Rezoning Transportation Analysis

Petition Number: 2022-139

Revision Log:

Date	Description
1-25-23	First Review (TM)

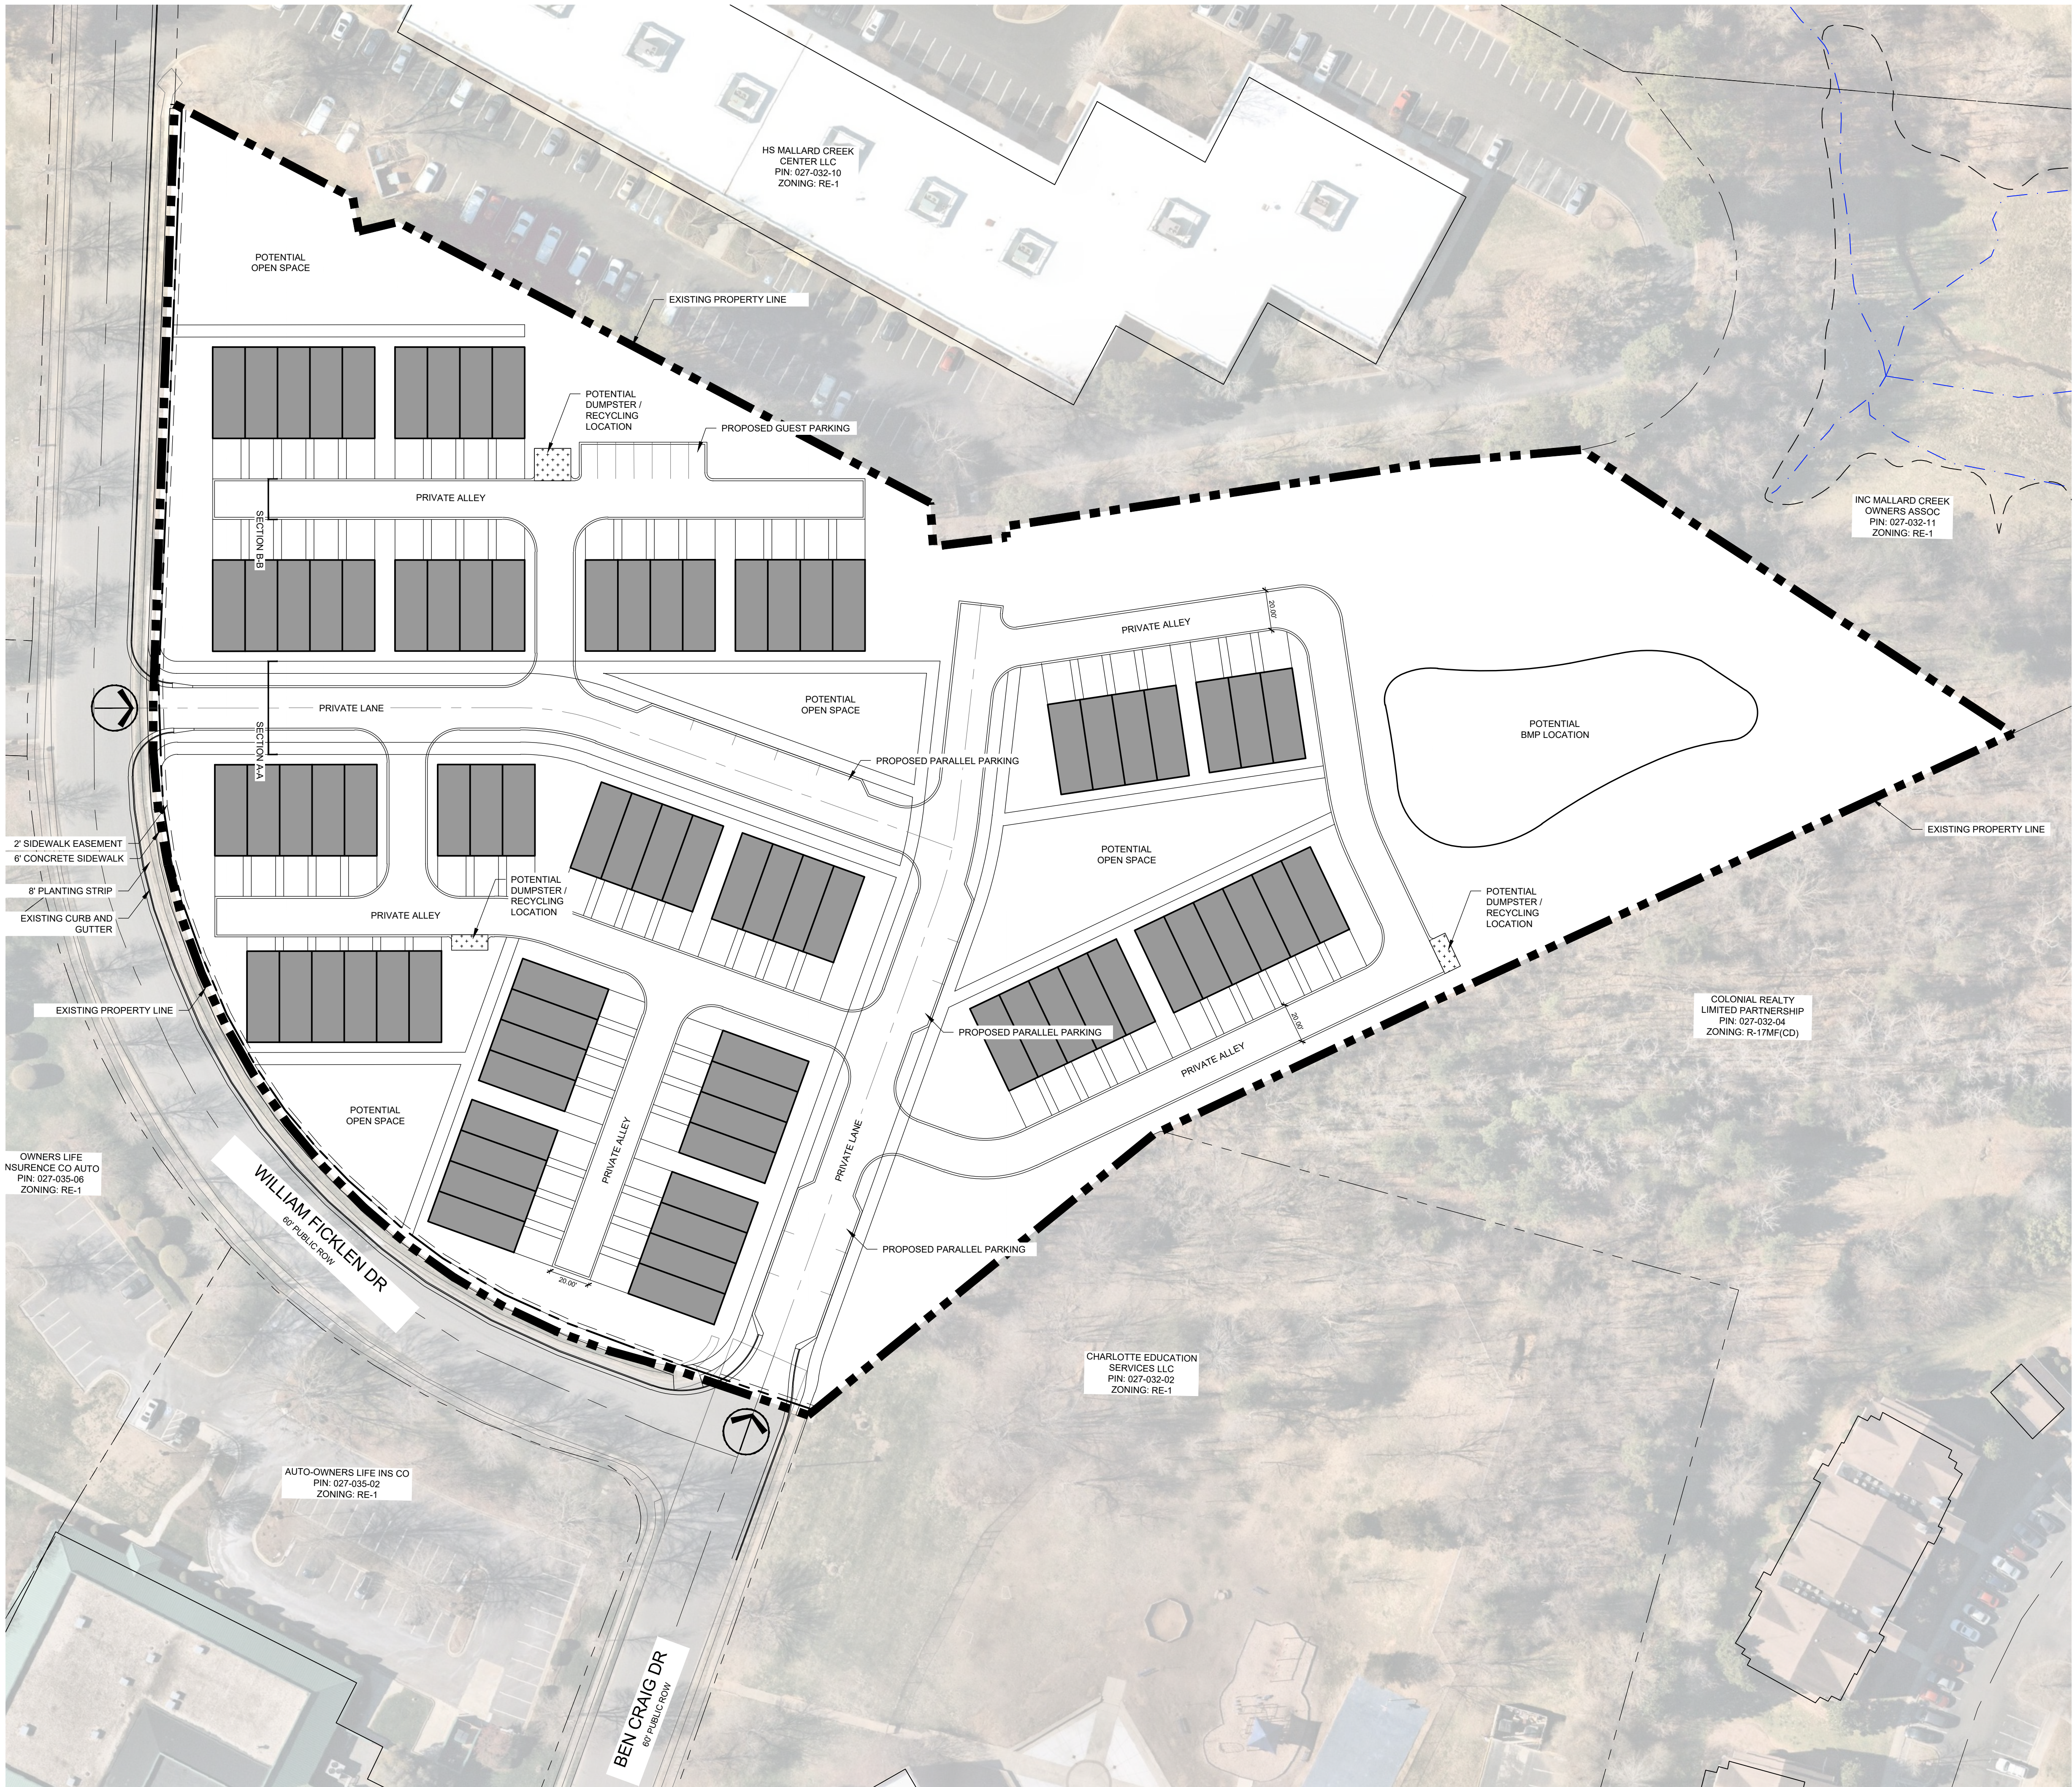
1. Curbline:

- a. **William Ficklen Drive:** The future location of curb and gutter is in its existing location.

NOTE: Additional distance from center line to back of curb may be required in locations where a median is present or around intersections and interchanges.

Label and dimension the curb and gutter from the centerline for each road on the site plan.

3. Revise conditional note(s) to commit to construct an 8-foot planting strip, and 6-foot sidewalk on Road William Ficklen Drive per Chapter 19. The site plan shall label and dimension both items from the back of curb and gutter or edge of pavement.

5. Revise conditional notes to commit to meeting all Intersection sight distance requirements along William Ficklen Drive frontage. If ISD cannot be met changes to site access will be required.

6. Revise site plan and conditional note(s) to commit to revising the internal private North/South and East/West "private lane" to be constructed to public street standards, with appropriate cross section, as network required streets per coordination with Subdivision.

7. Revise conditional note(s) to commit to meeting intersection sight distance requirements. Site entrance locations will be required to meet all ISD requirements.
8. Revise site plan to show proper separation between the proposed on-street parking and the intersection. A minimum of 20-feet is required from the curb return to the parking stall.
